PLAN REVIEW SHEET

Petition #: RZP 2022-200

Address: IBM Drive

Request: UR-2 (CD)

RZ-2

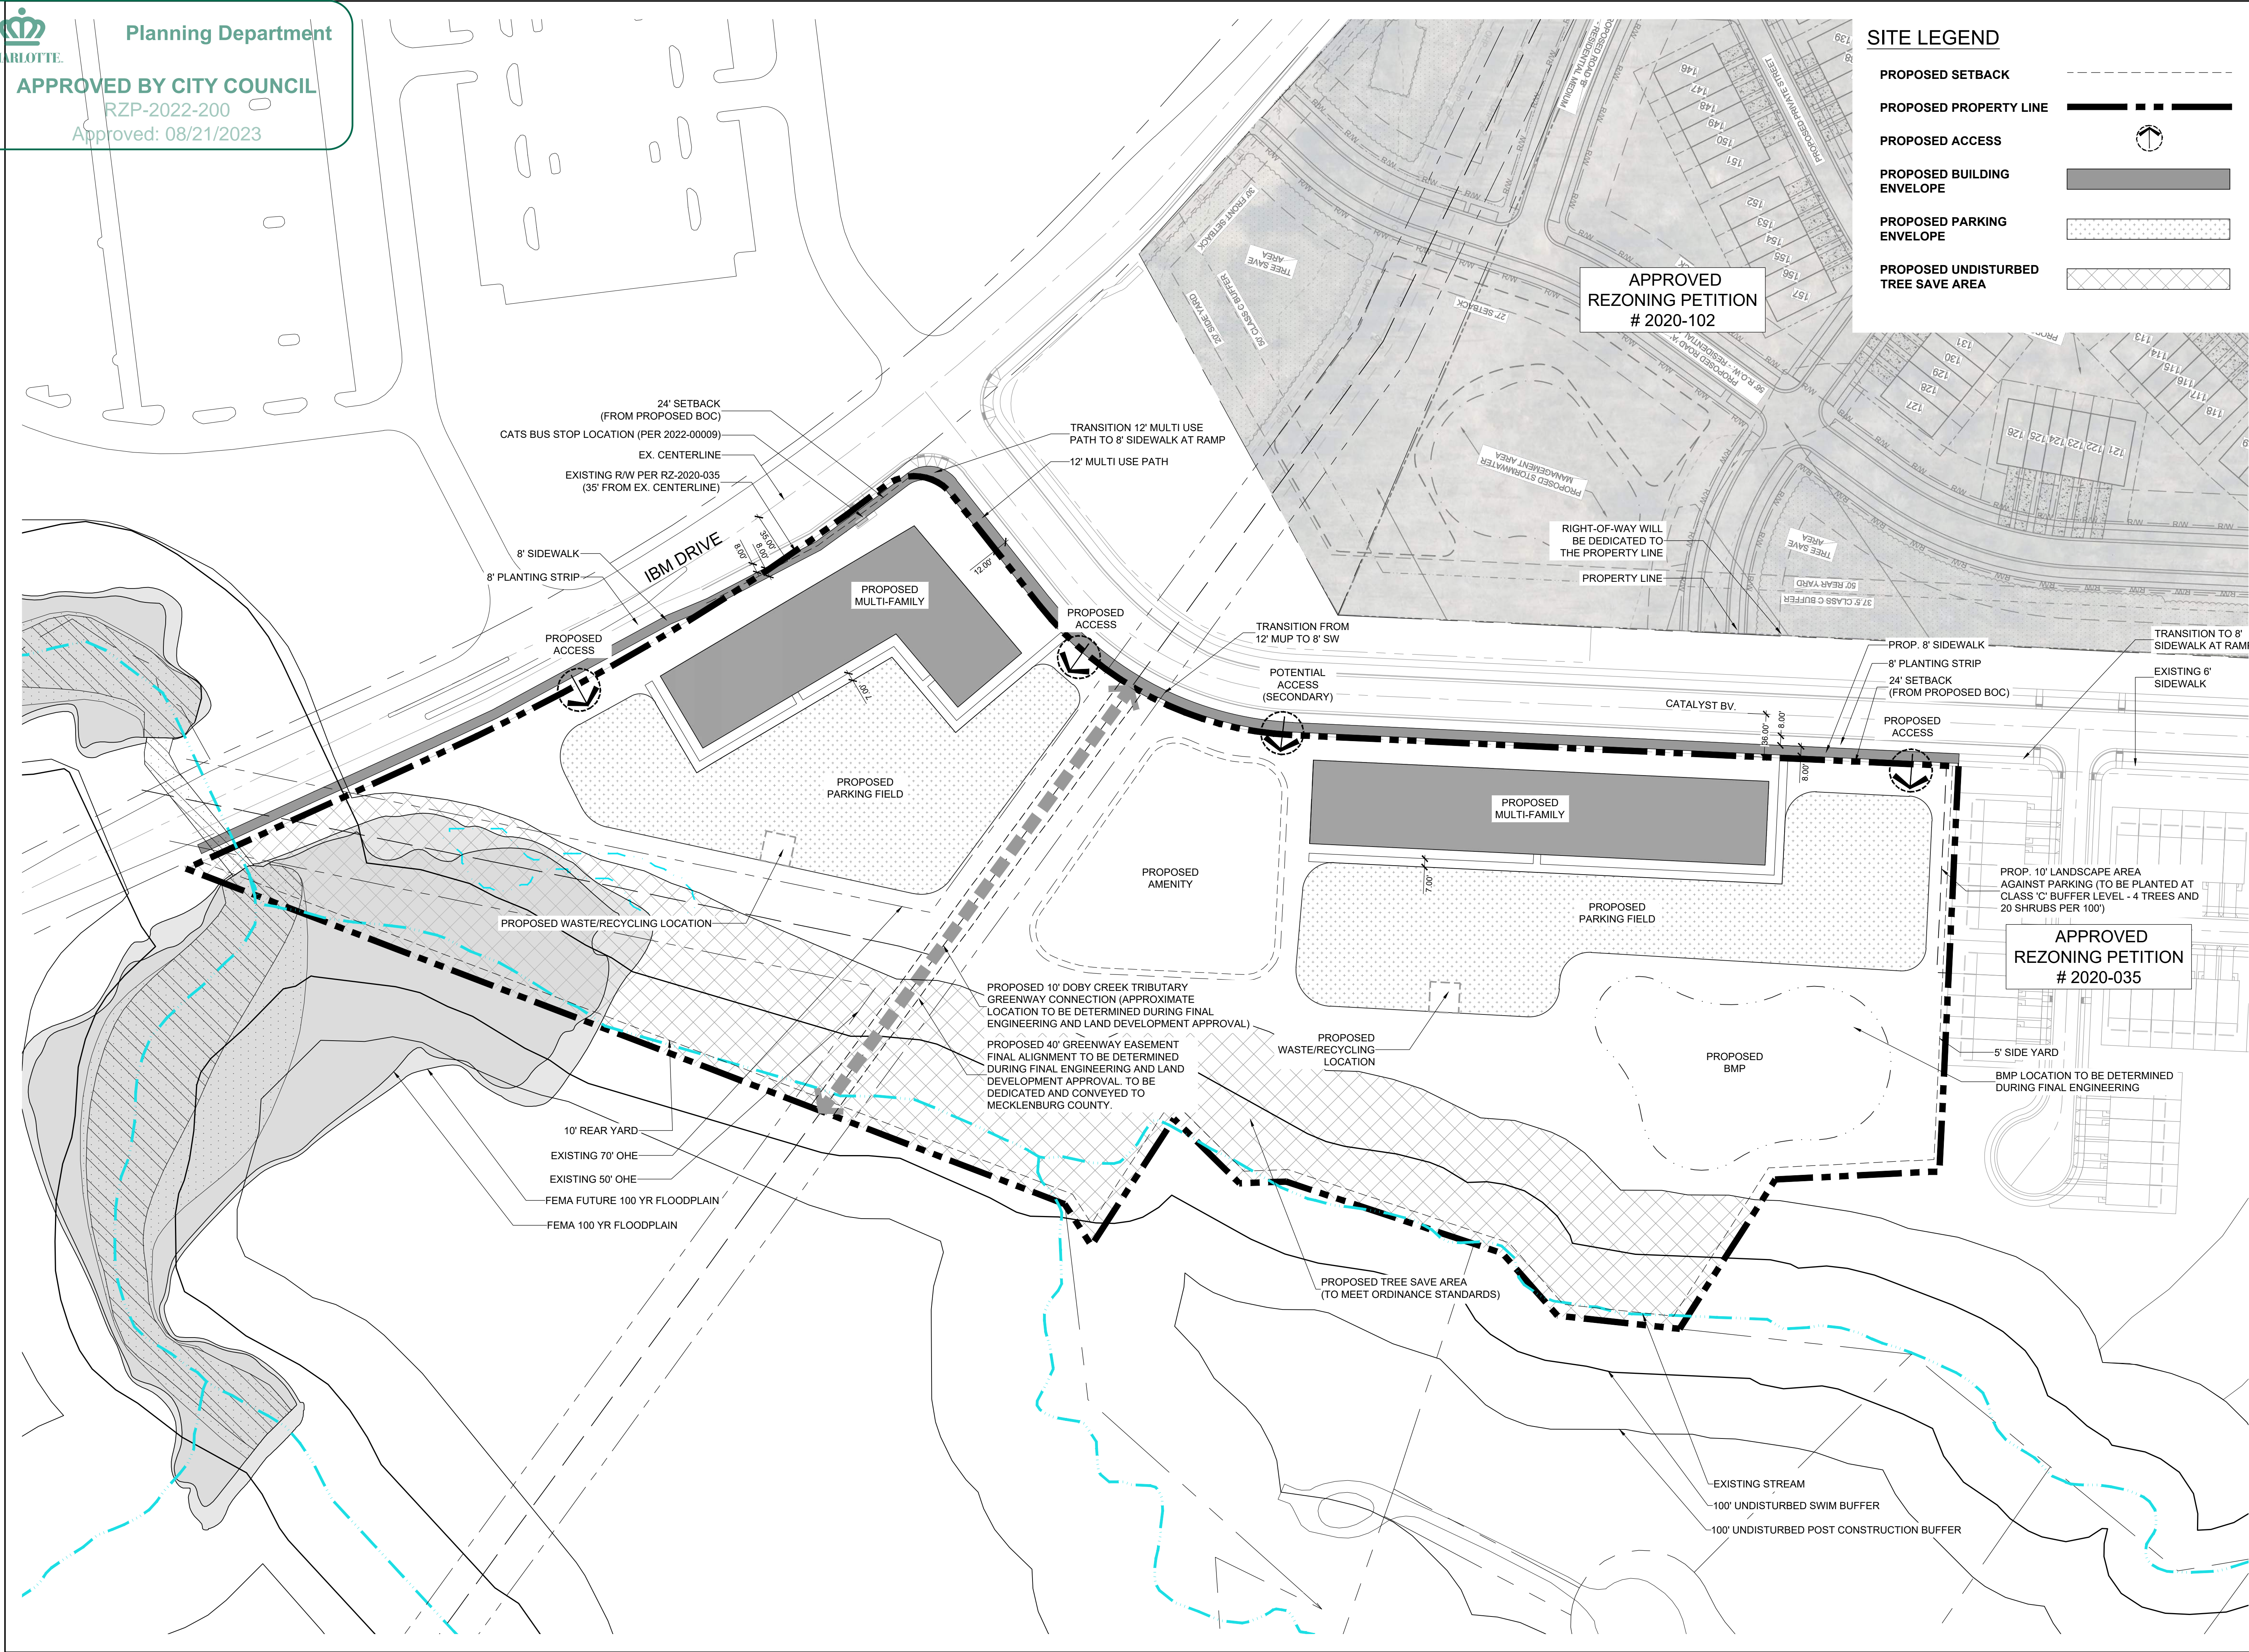
The site is located along CATS local bus route #54 on IBM Drive. CATS requests the construction of ADA compliant bus standard detail 60.03A on IBM Drive. The final location will be coordinated with the developer during the Land Development plan review process.
